Development Facilitation Team (DFT) – Review Comments

Project No: PR-2023-008552 Date: 07/12/2023 Agenda Item: #2 Zone Atlas Page: K-15

Application For: VA-2023-00171 – IDO WAIVER TO SIDEWALK AND BUFFER WIDTHS (DHO)

DRB Project Number: 2023-008552 Hearing Date: 07-12-2023
Project: Residence Inn & Food Hall Agenda Item No: 2

**Titan Food Hall and Residence Inn: Central Avenue Sidewalk and Landscape Waiver Exhibit**

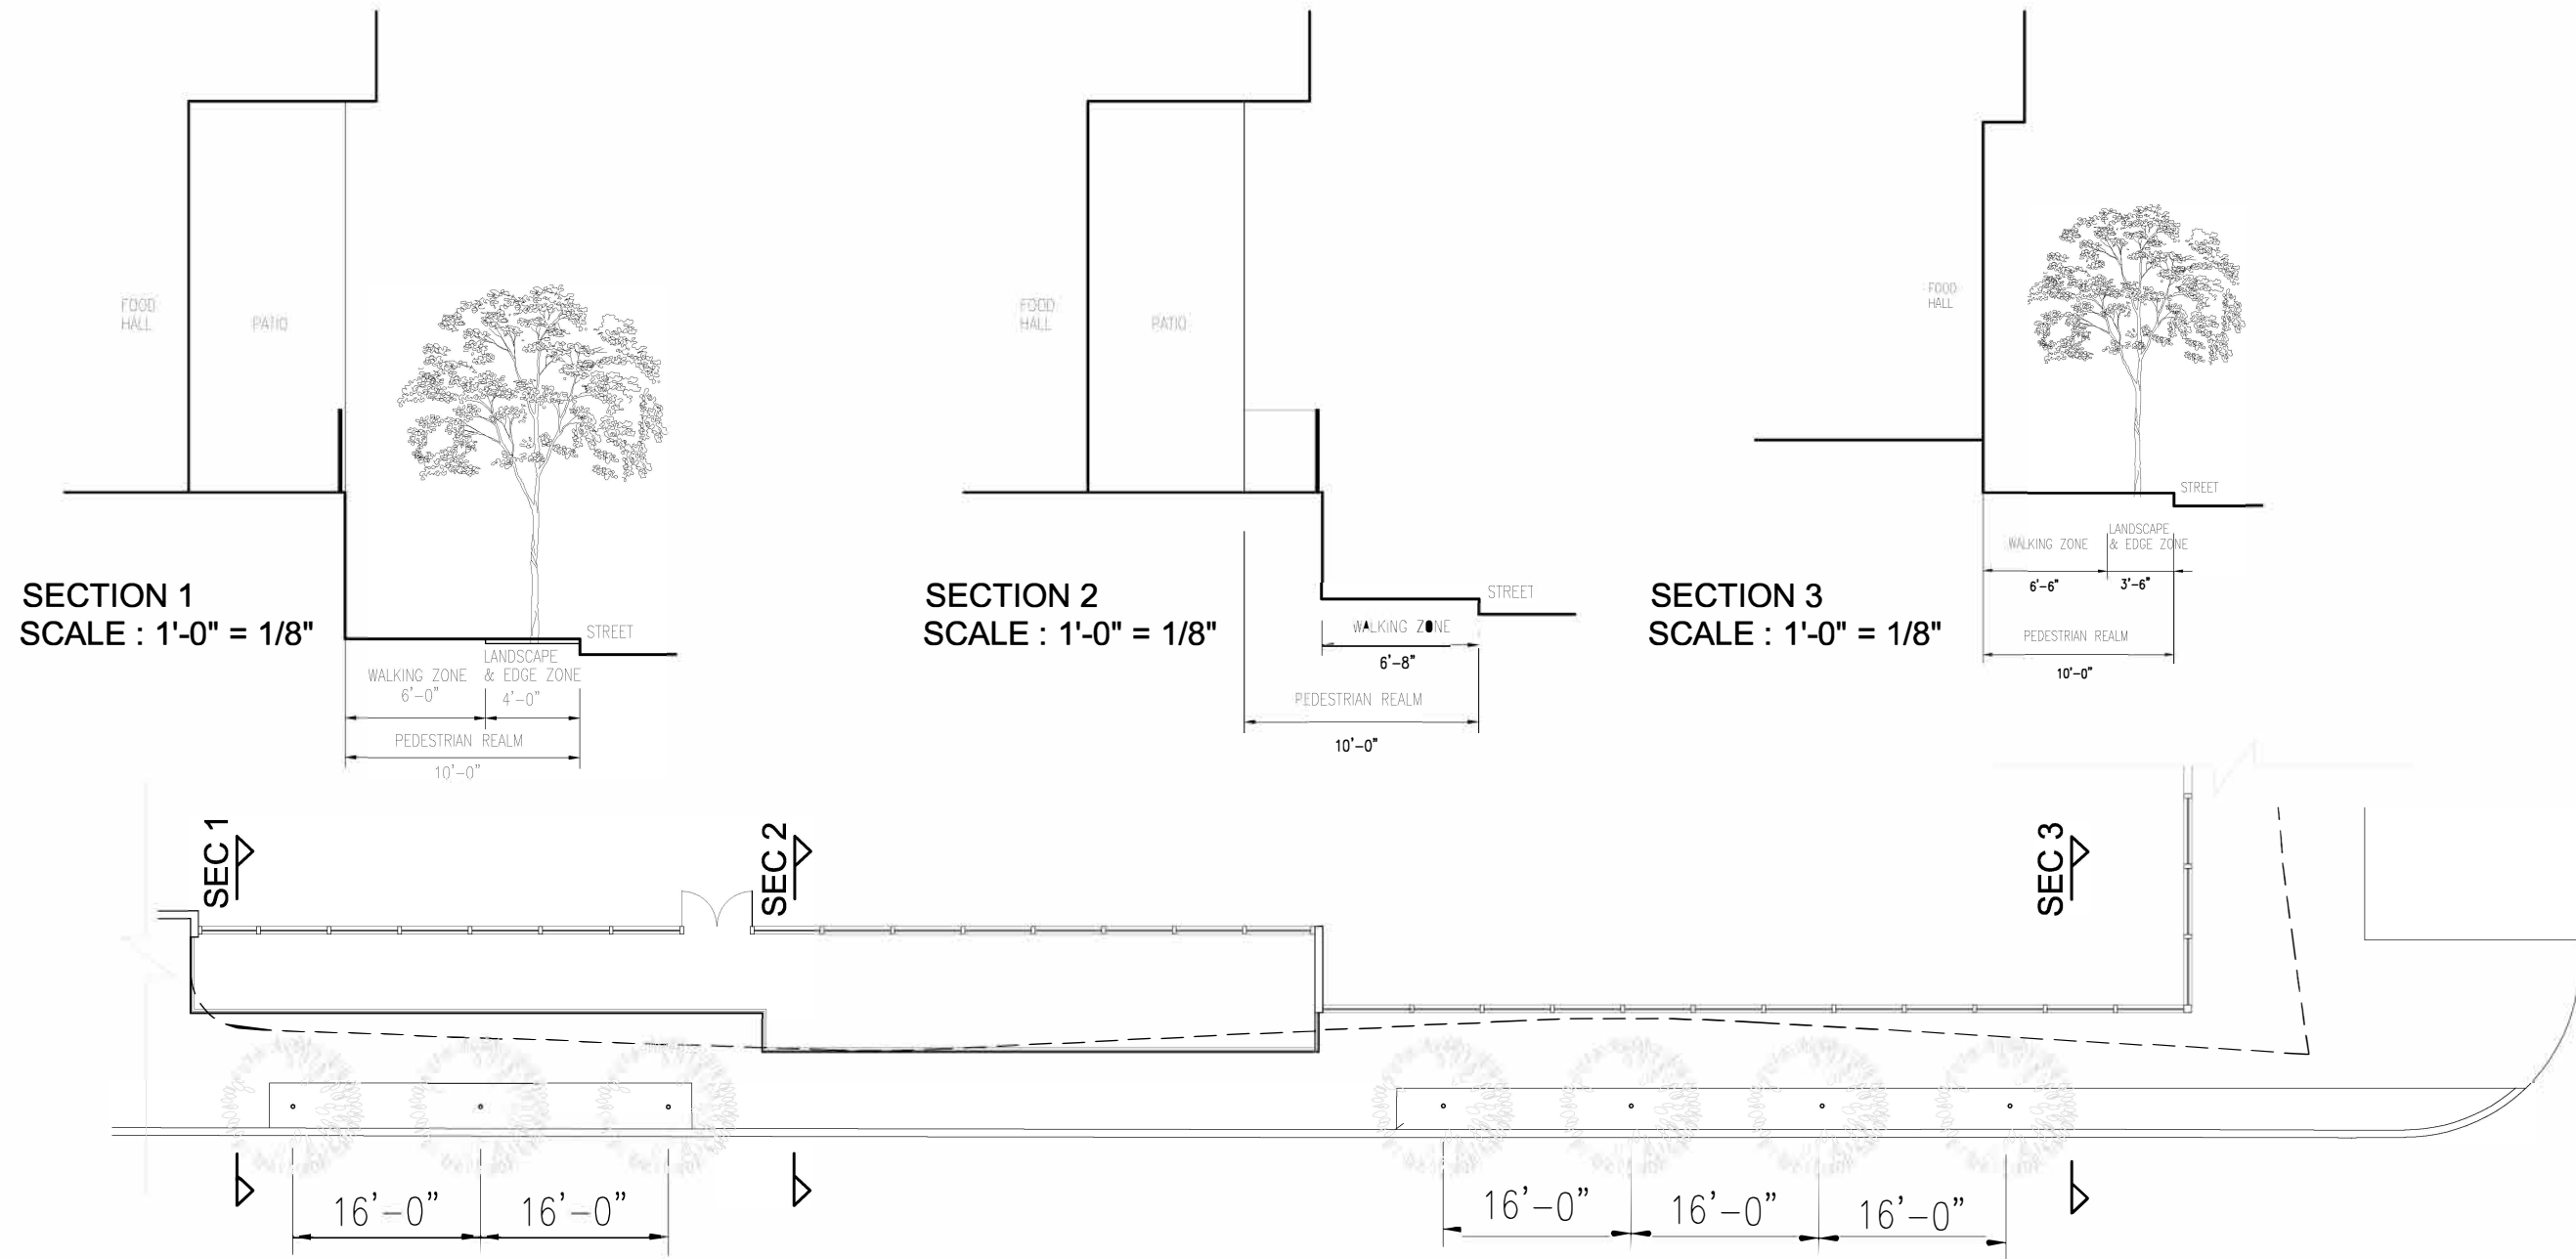
- Per **IDO 5-3(D)(2)(b) Sidewalks in Mixed Use Development** and **DPM 7.2.29** for Central as a Main Street, outside of a Center, 10-foot-wide sidewalks with a 5-6-foot landscape buffer zone are required.
The project team is requesting a Waiver on sidewalk width requirements as the project team believes the current design fulfills the purpose of improving walkability and the pedestrian experience. The landscape buffer zone width can be a DHO Determination.

- Applicant is proposing the following design for the project frontage along Central Avenue:

Titan Food Hall and Residence Inn: Central Avenue Sidewalk and Landscape Waiver Exhibit

The Applicant articulates that the uses proposed are consistent with the MX-M zone and provide excellent connectivity (via the skybridge and Central Avenue) to the adjacent multi- 3 family, hotel, and hospital uses. The proposed design along Central Ave. will still provide an appropriate sidewalk and landscape buffer.

The sidewalk was developed as part of the ART project and provides adequate sidewalk area that is complemented by outdoor dining. There is no gap in the sidewalk system.
